Development: Re-submission of AW/299/24/HH - Demolition of the existing porch and detached garage. New rear/side flat roof extension, front porch extension. Conversion of the first floor roof space with new rear dormer. Installation of 2 x side windows.

Location: 8 Cherry Close Aldwick PO21 3BA

I regret that I am unable to accept your documents as a valid application until the following item(s) have been received or resolved :-

PROPOSED ELEVATIONS

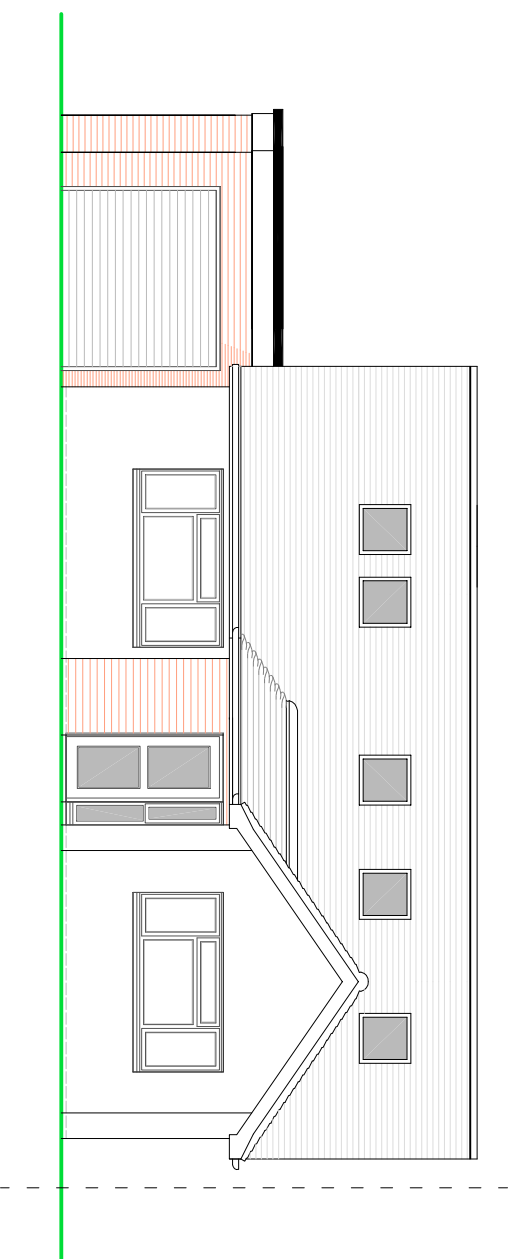
The proposed elevations dated 17/10/2025 appear to be a superseded version, please confirm we can remove this drawing from the application.

PROPOSED ELEVATIONS

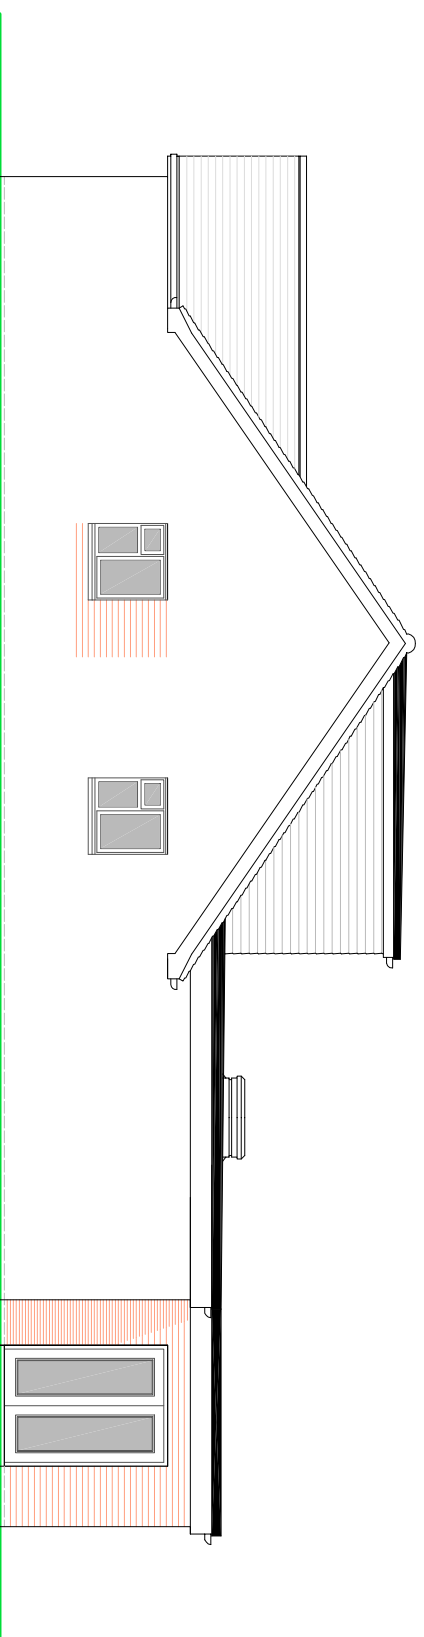
The store window shown on the proposed rear elevation is missing from the proposed ground floor plan, please review and amend.
